Ribble Valley Borough Council
Housing & Development Control

Application no: **3/2024/0187**

Address: **Clayton Manor Ribchester Road Wilpshire BB1 9HU**

Proposal: **Proposed construction of four one-bedroom apartments in a purpose-built detached building with access off Ribchester Road, following demolition of existing garage. Resubmission of 3/2023/0930.**

PROPOSED CLAYTON MANOR APARTMENTS SITE LAYOUT

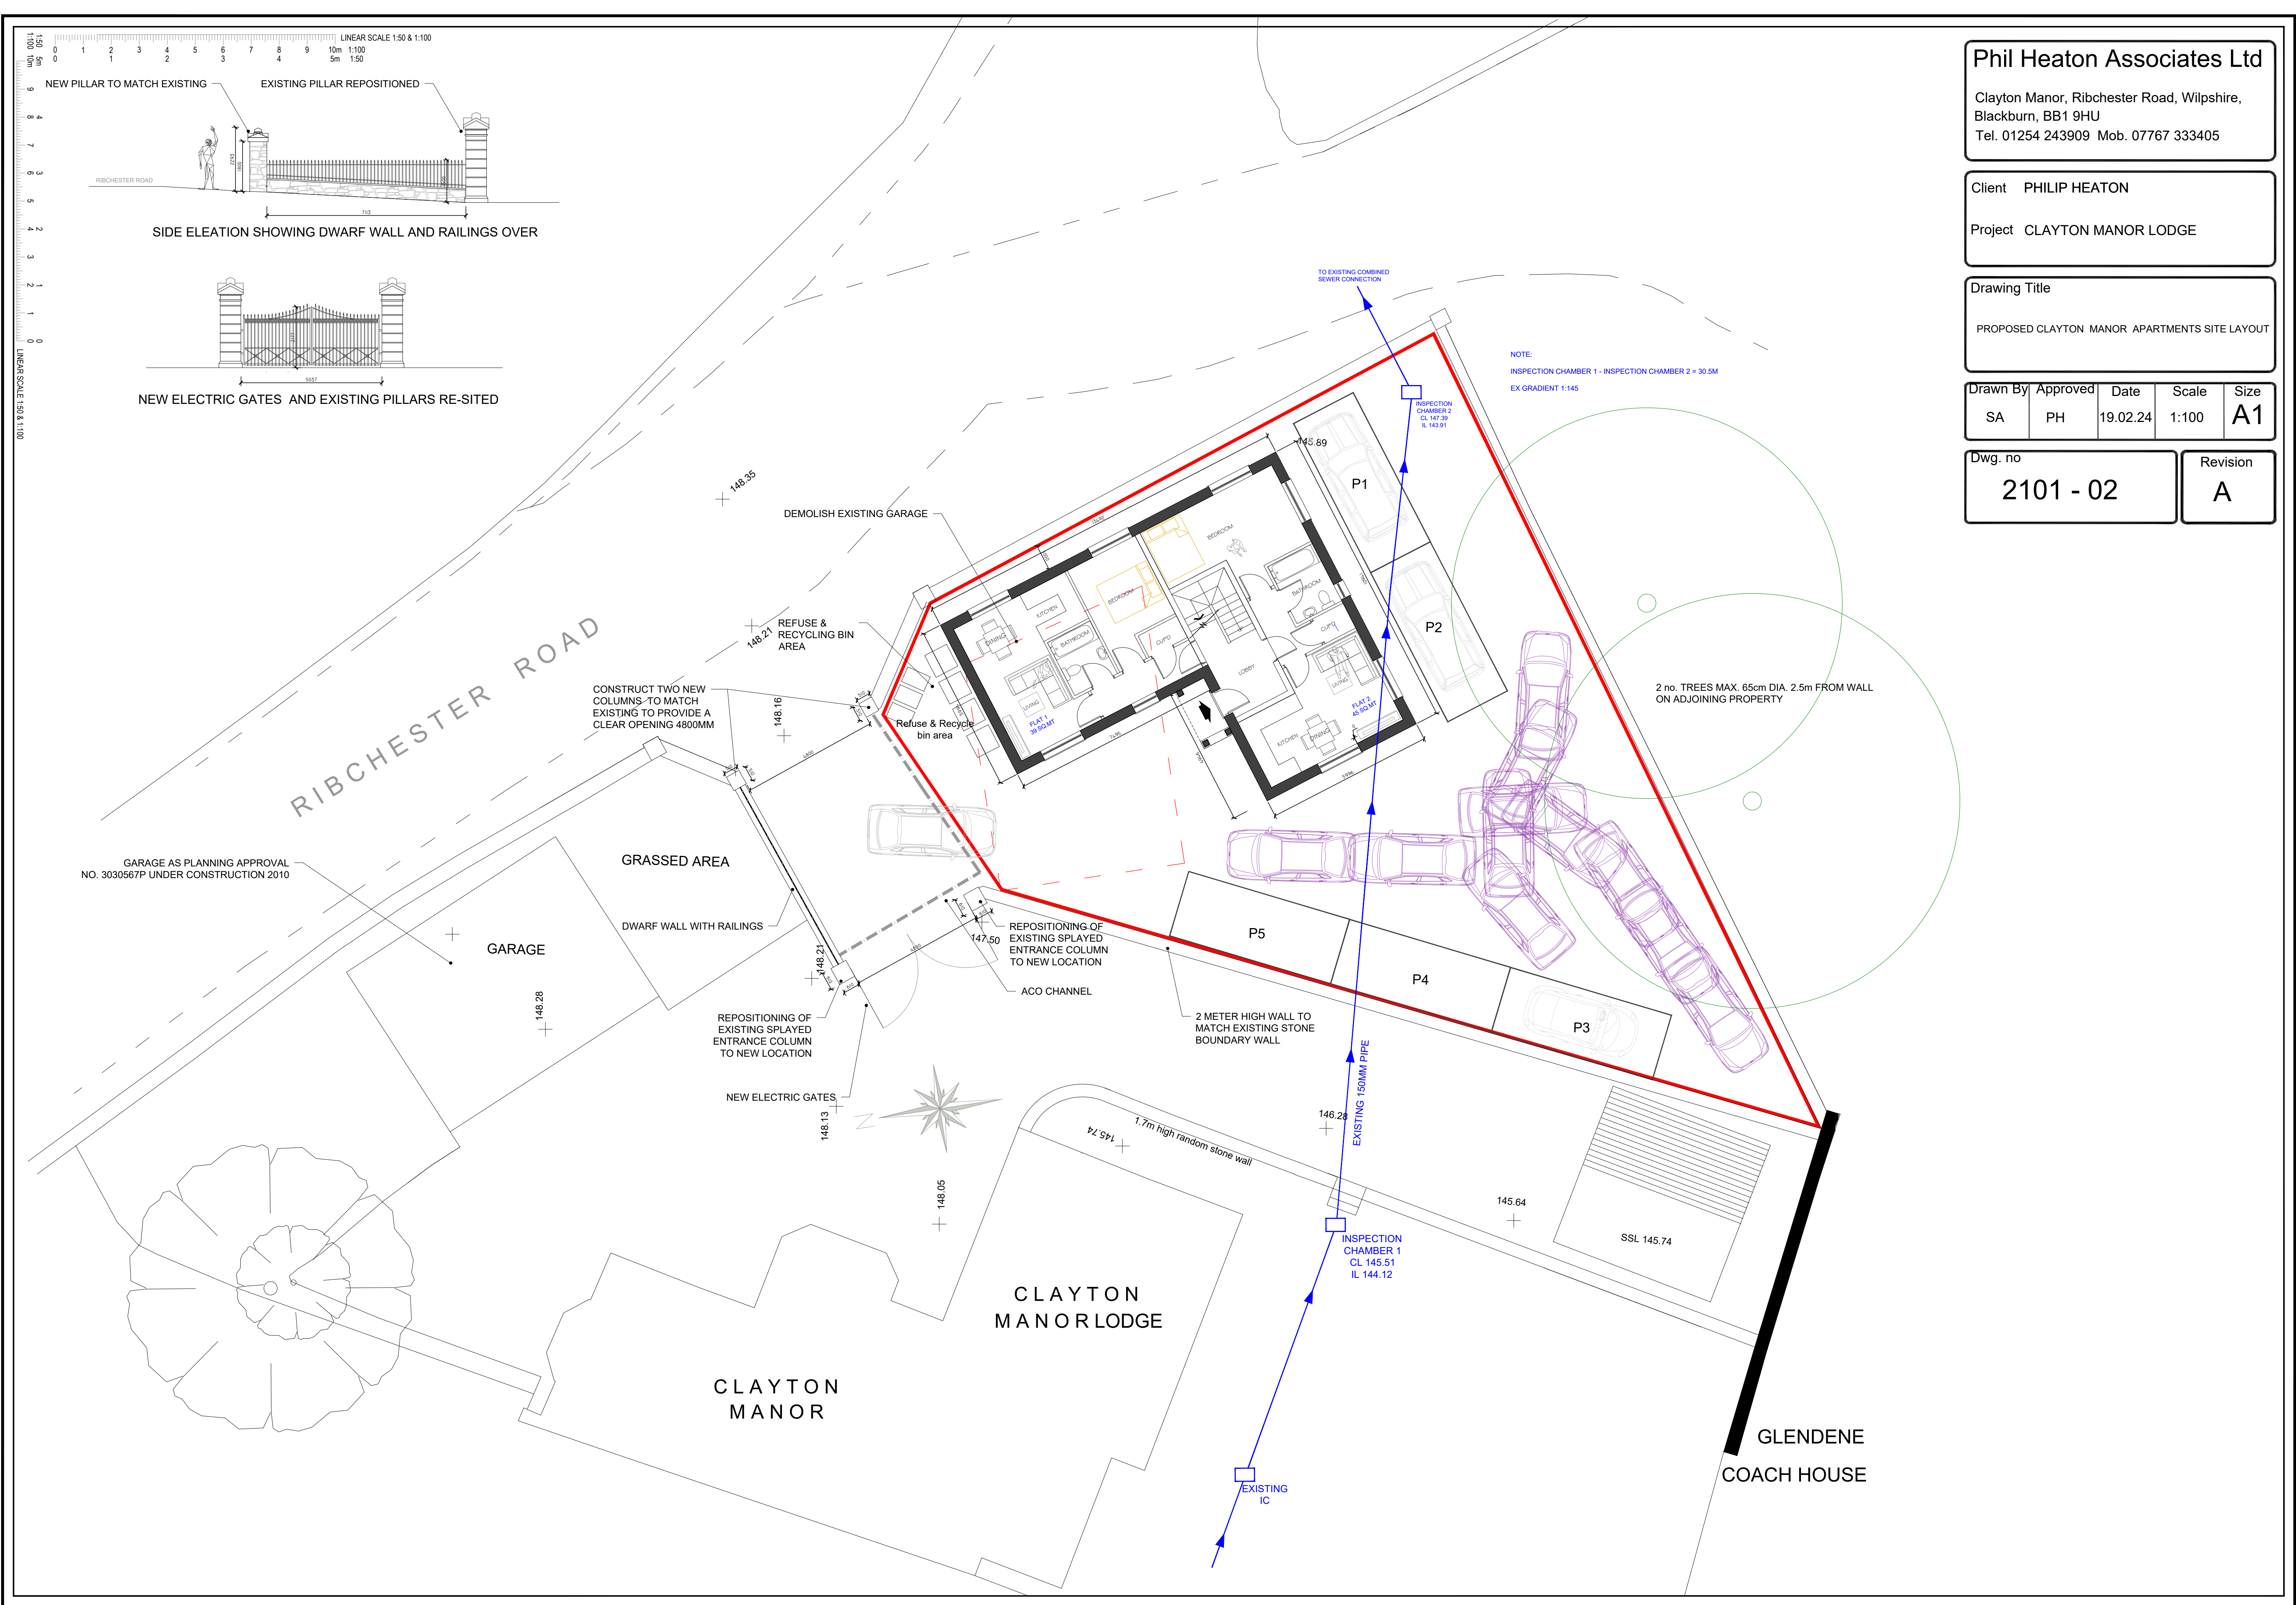
The LHA have reviewed Phil Heaton drawing number 2101-02 titled "Proposed Clayton Manor Apartments Site Layout" and require the site access to be a minimum of 5.5m wide, up until the access reaches the gated access which serves Clayton Manor, approximately 11.5m away from the adopted carriageway. The LHA require the access to be this wide to ensure that there is adequate space for vehicles to turn into the proposed site and to ensure that there is space for two vehicles to use the access simultaneously. As a result of this, the LHA require an amended plan to be submitted.

On the amended plan, the LHA require a visibility splay drawing to be provided. The LHA require visibility splays of 2.4m x 43m to be provided in both directions, given the speed limit of Ribchester Road.

The LHA have reviewed Phil Heaton drawing number 2101-02 titled "Proposed Clayton Manor Apartments Site Layout" and are aware that each apartment will have access to one car parking space, which complies with the LHAs parking guidance. However, the LHA require changes or further information to be submitted to support the positioning of the car parking spaces.

Firstly, the LHA require car parking space P2 to be relocated adjacent to P1. This is because currently, the car parking spaces are provided in tandem which could lead to parking space, P1, being obstructed should the vehicle want to exit the site. Therefore, to prevent any obstruction, the space should be relocated.

Secondly, the LHA require a swept path drawing of a vehicle entering and exiting car parking spaces P3-P5. The LHA require a swept path to be provided to ensure that vehicles can exit the spaces without any potential conflicts, given the close proximity the spaces are to the apartment block.

The LHA also require a swept path drawing of a fire tender, using the provided turning area and exiting the site in a forward gear. The LHA require these details to ensure that the site has adequate space for the largest vehicle that will service the site.
